**A303 Sparkford to Ilchester Dualling
PINS Reference: TR010036**

Comments of the draft Development Consent Order 2019

**Submitted by South Somerset District Council
on 8th February 2018**

A303 SPARKFORD TO ILCHESTER DUALLING
WORKS PLANS REGULATION 5(2)(J)
SHEET 2 OF 4

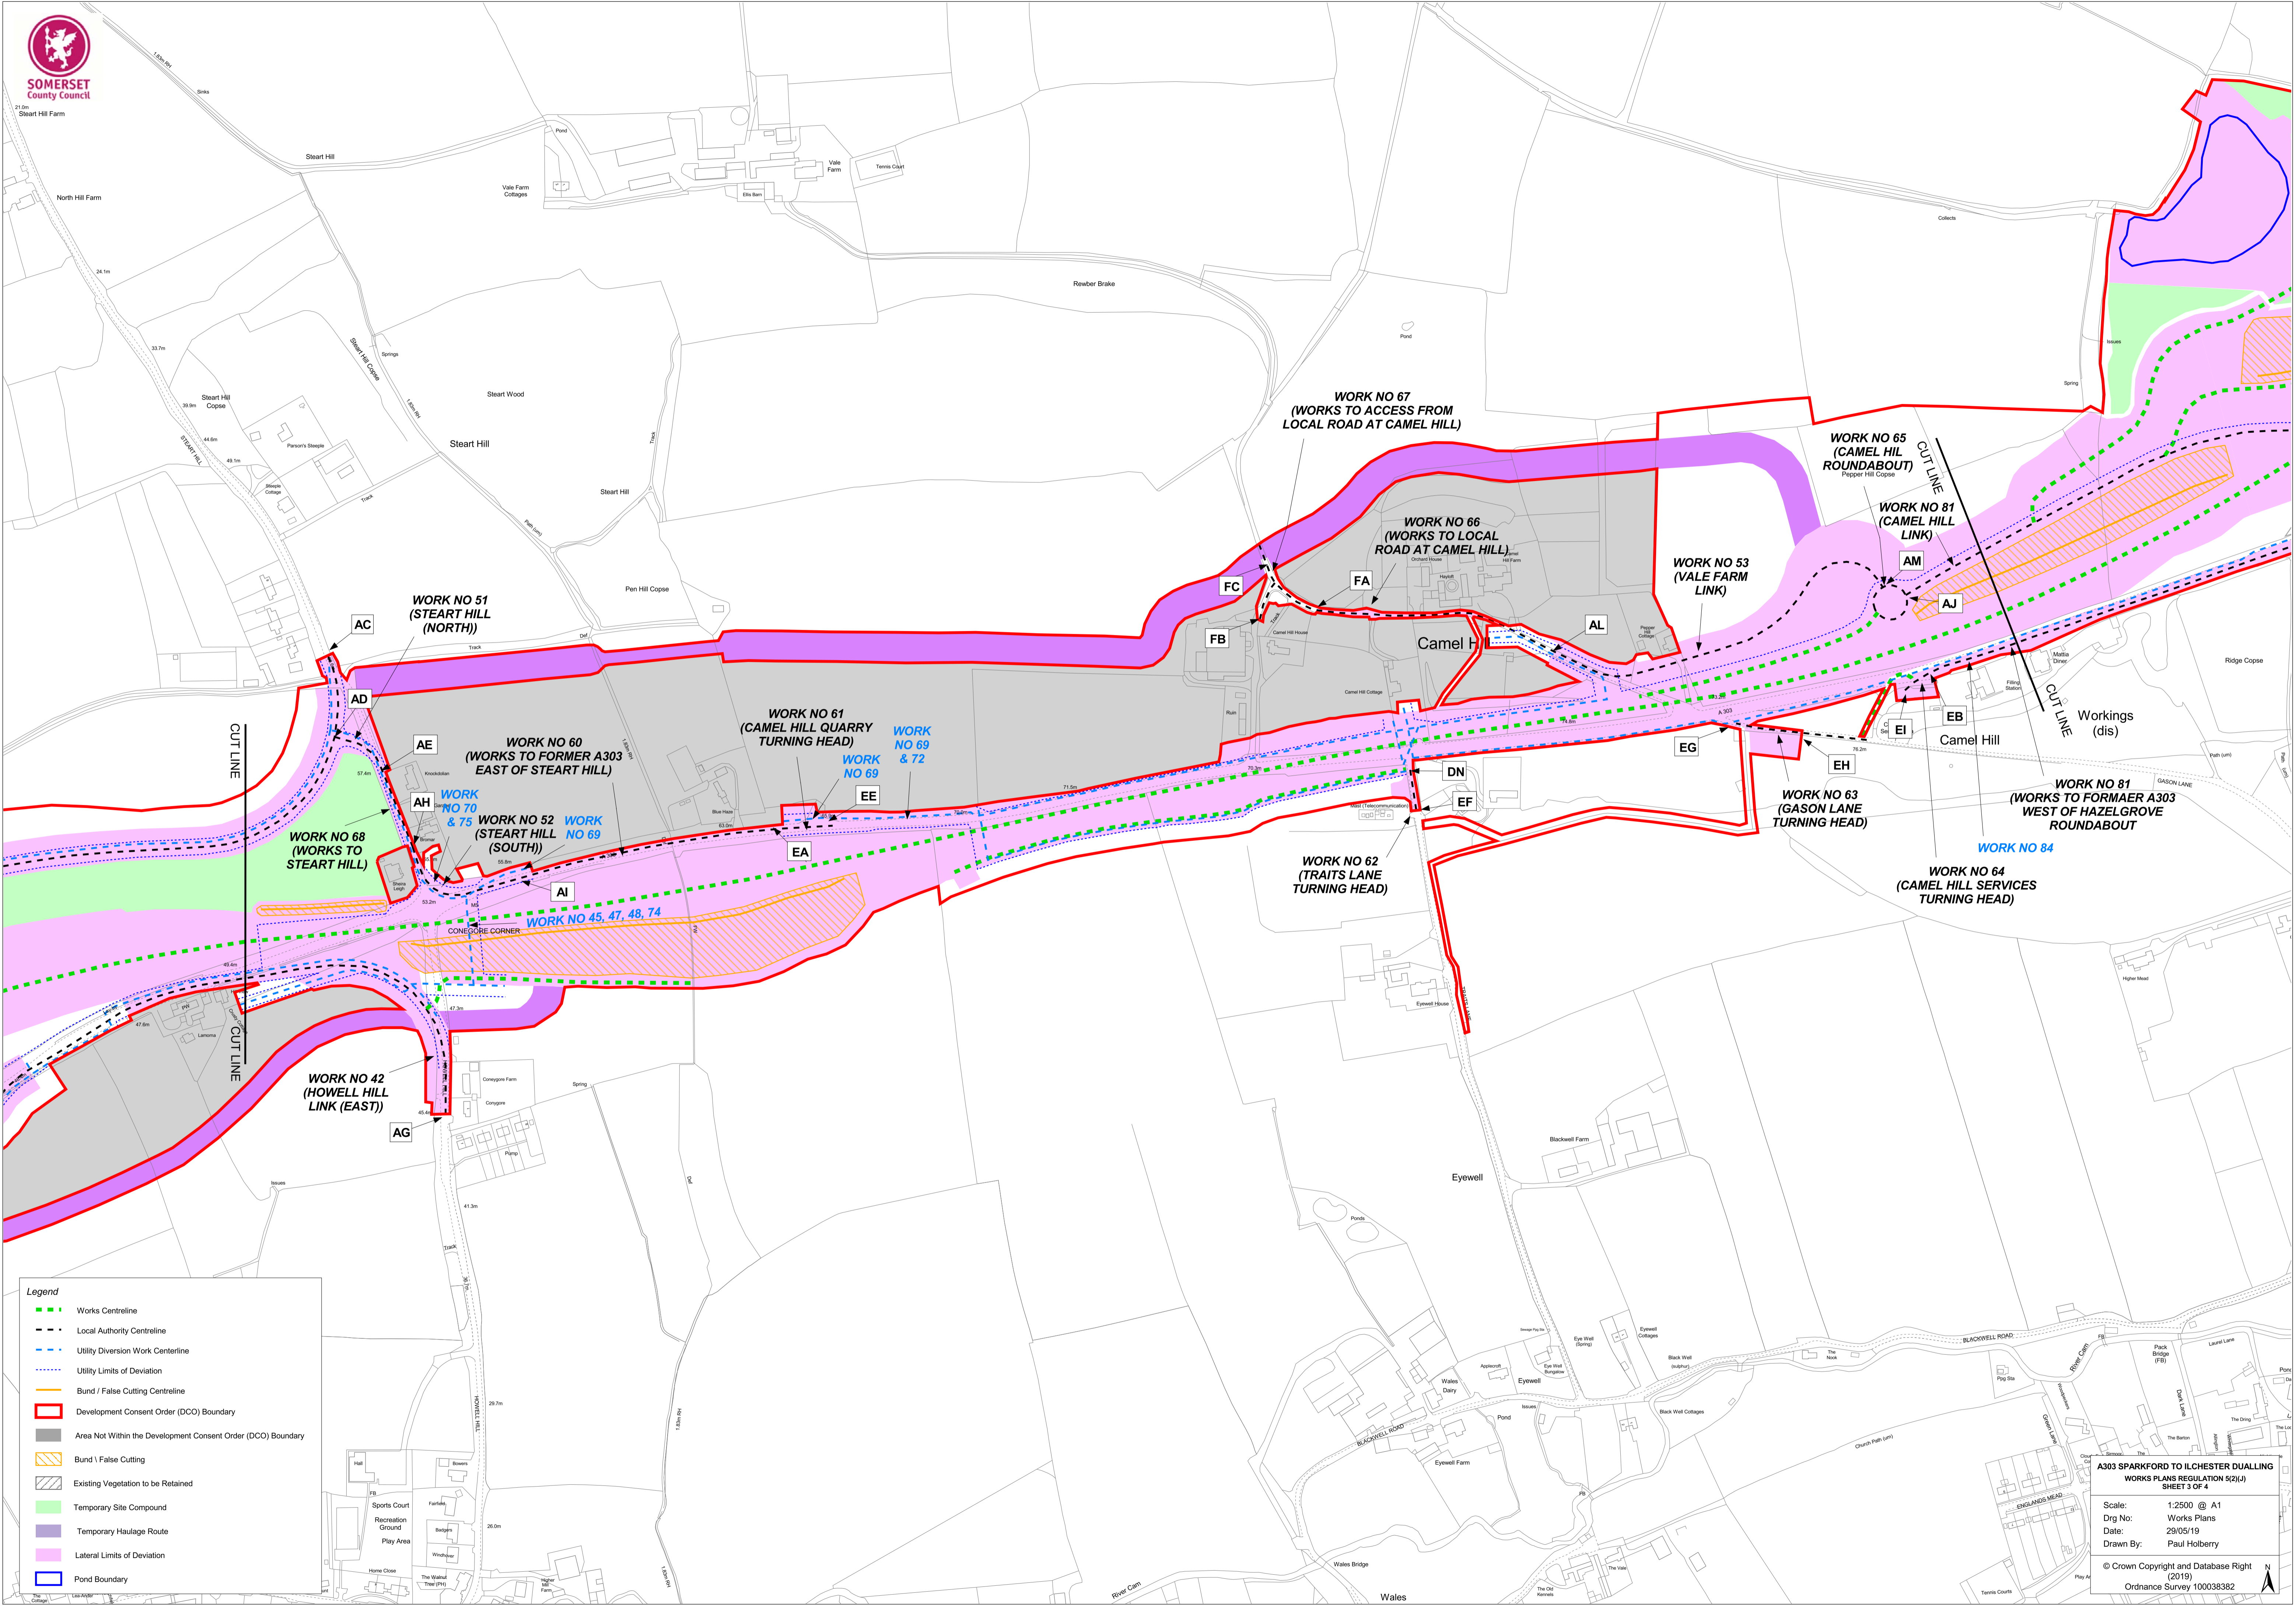
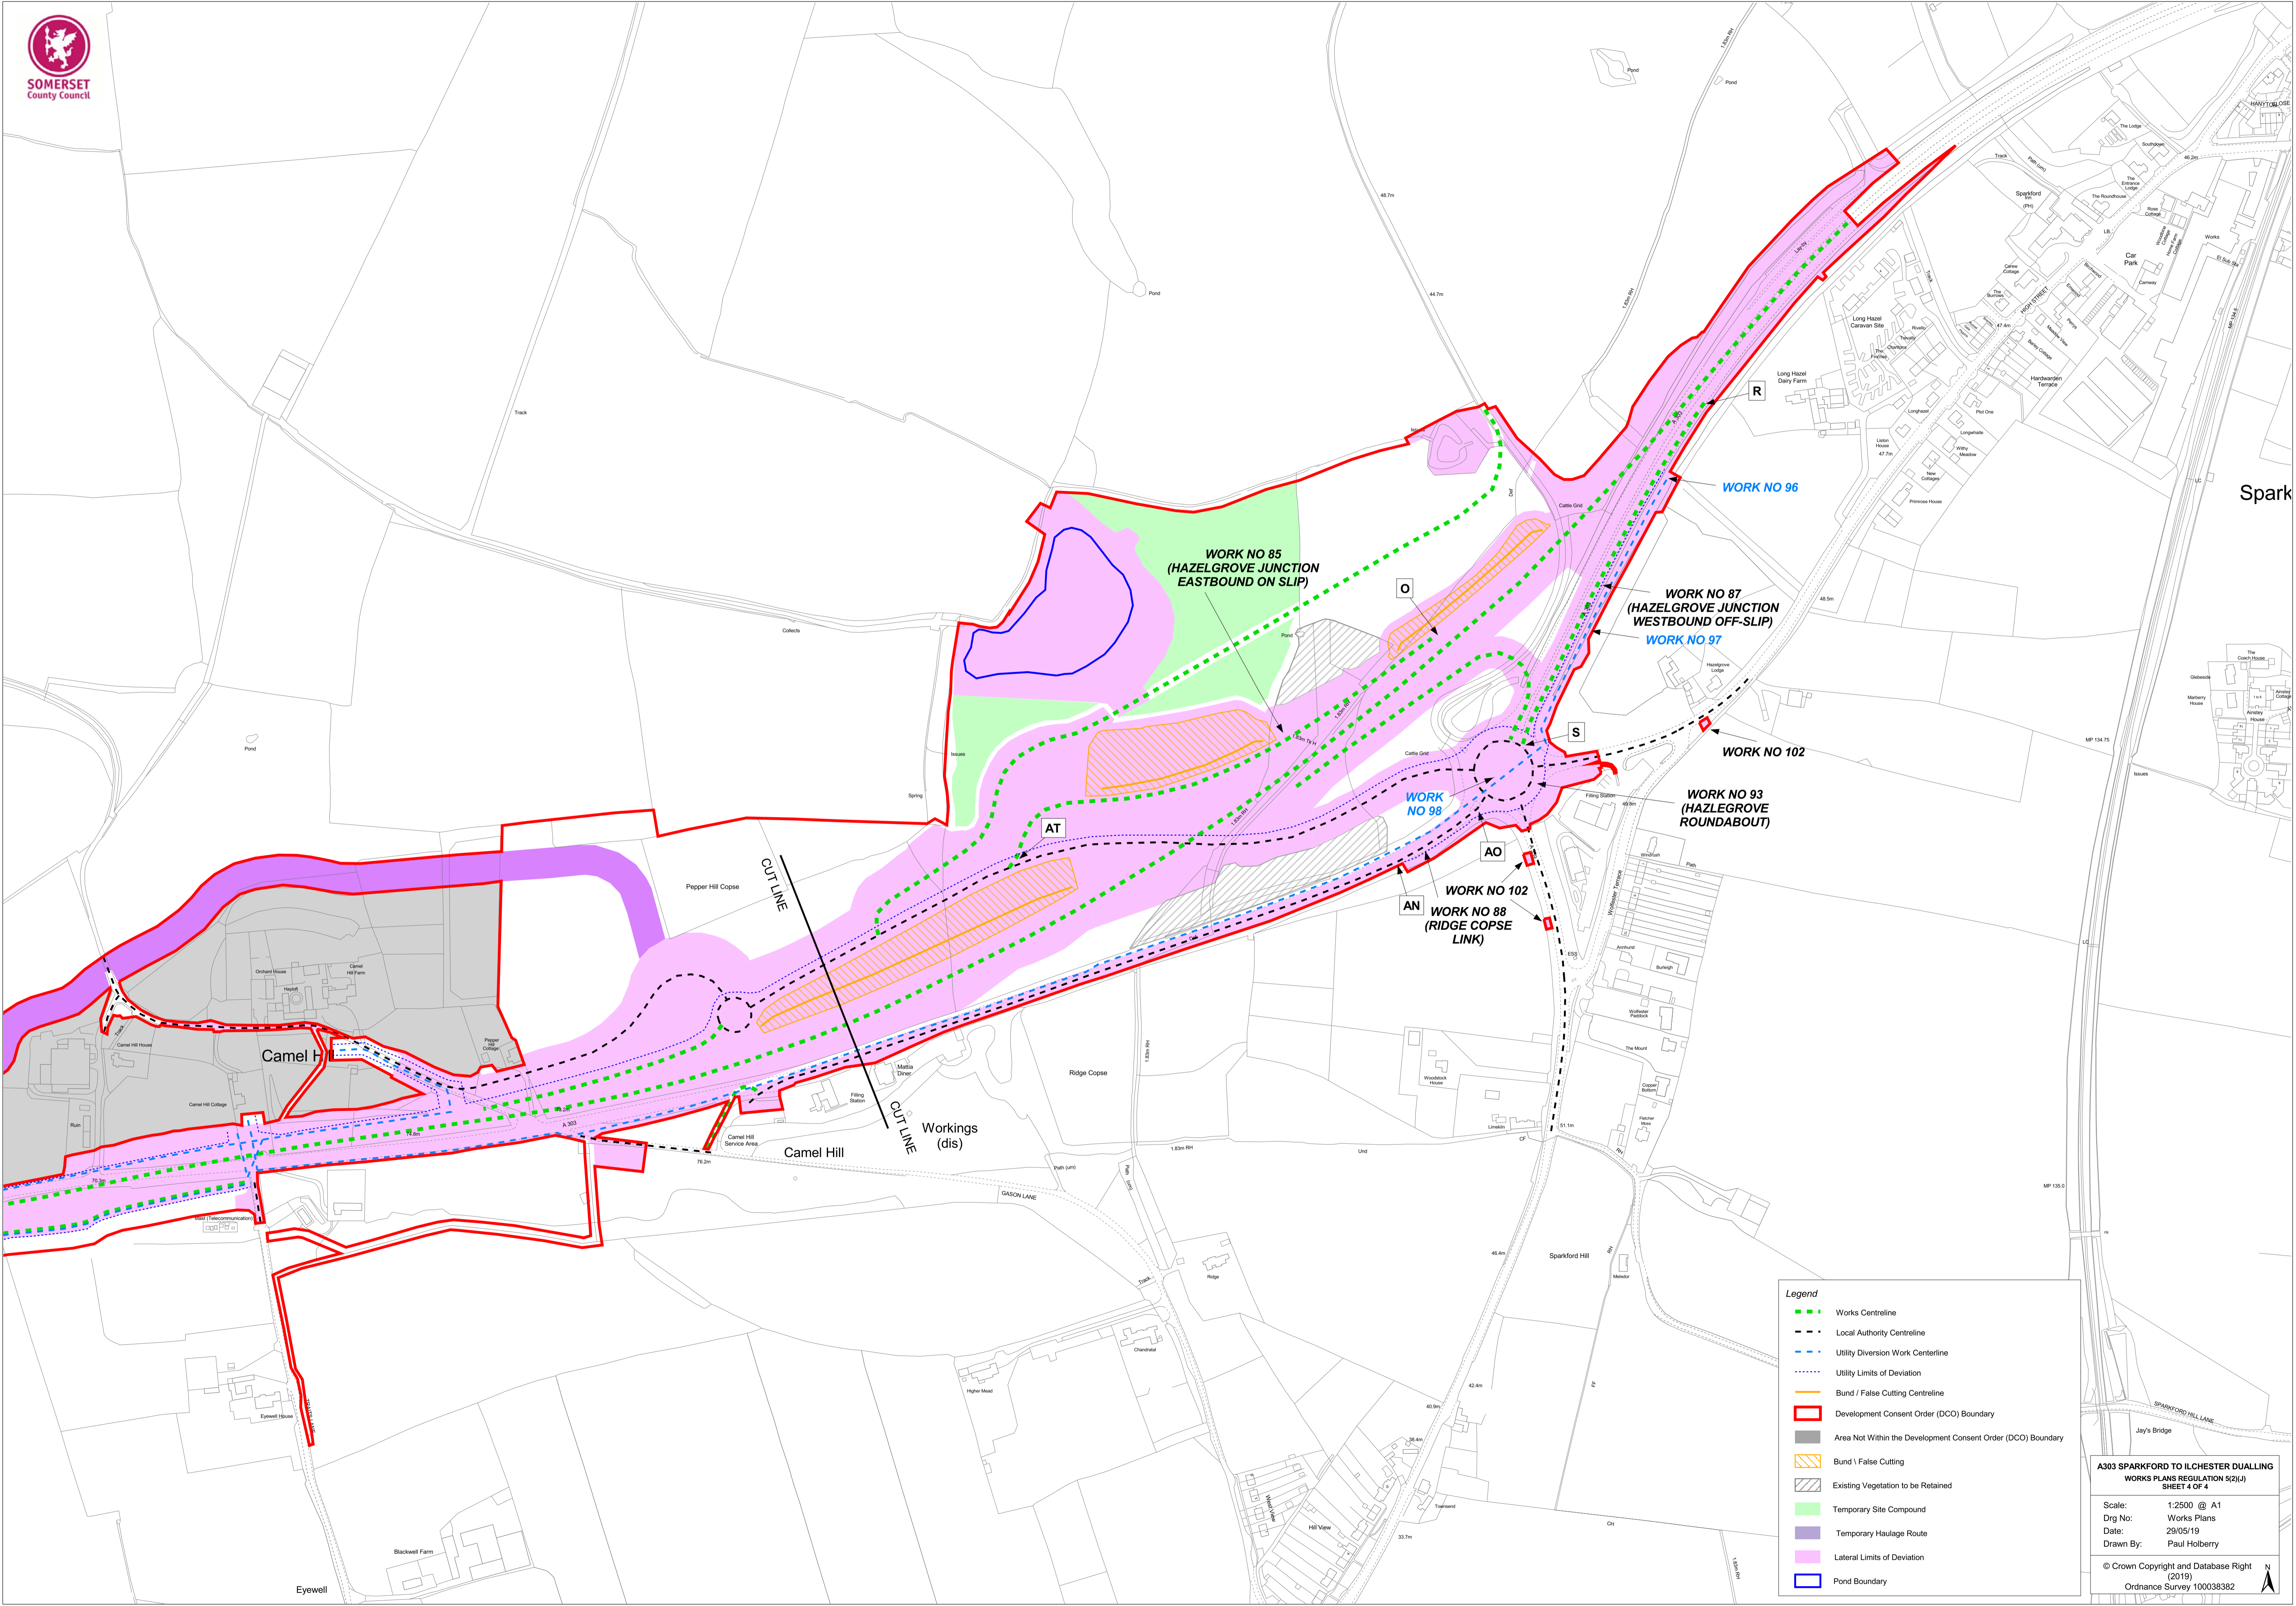
17.	Schedule 1 – Authorised Development	The District Council is seeking modification of some of the Works, i.e. relocation of Work No. 9, Pond 5.	The amendment will depend on discussions that are currently on-going
